## **ADDENDUM NO. 4**

**Date:** April 13, 2017

**Project:** Hall Elementary School  
Portland Public Schools/City of Portland  
Portland, Maine

9 CURTAINWALL SILL AT BRICK VENEER (TYP)

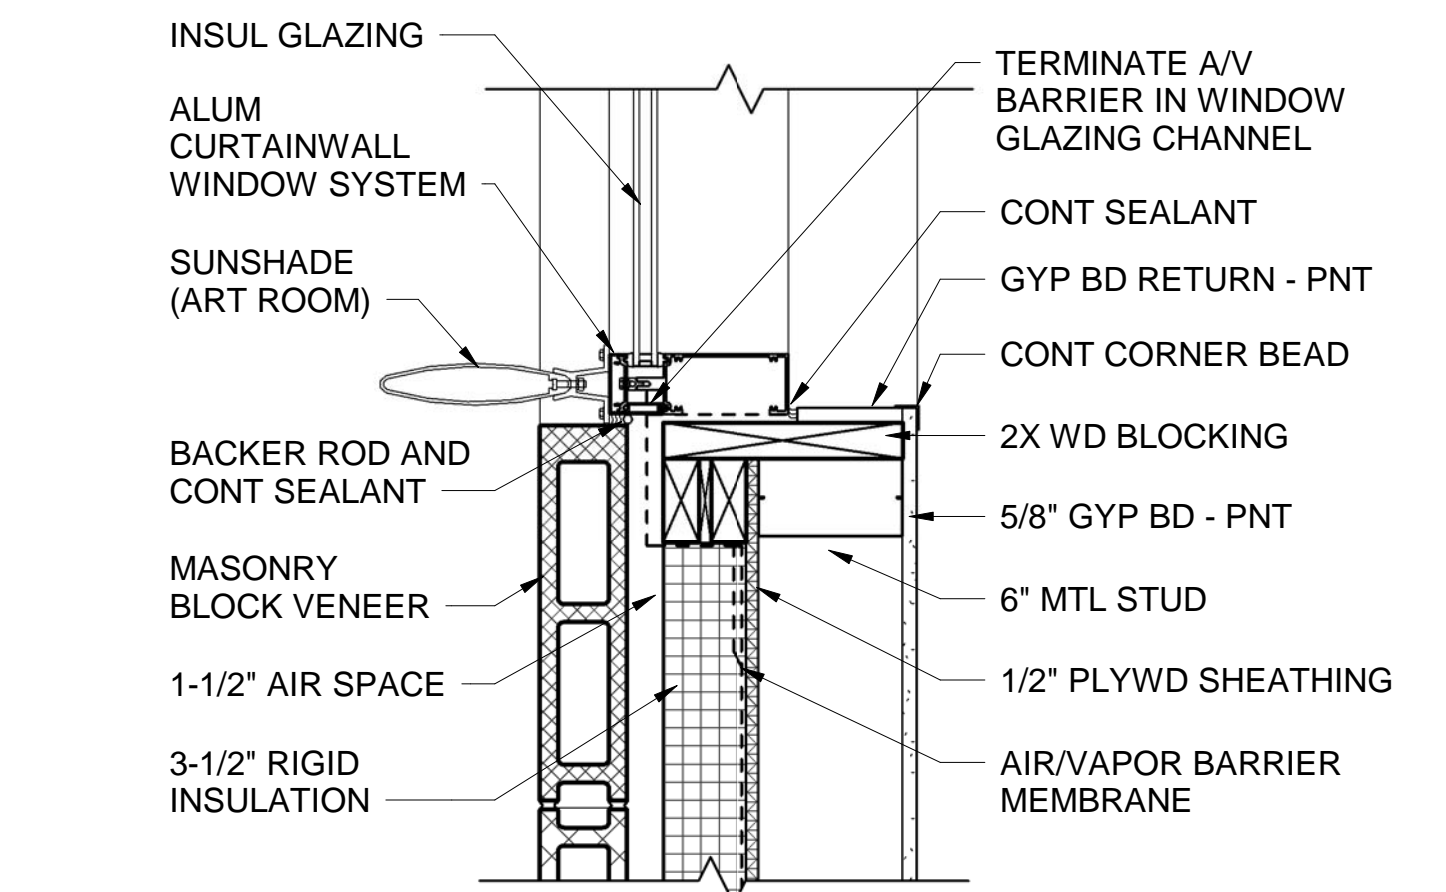
1. Detail 9/AE621: The sill on this detail will be a rowlock brick.
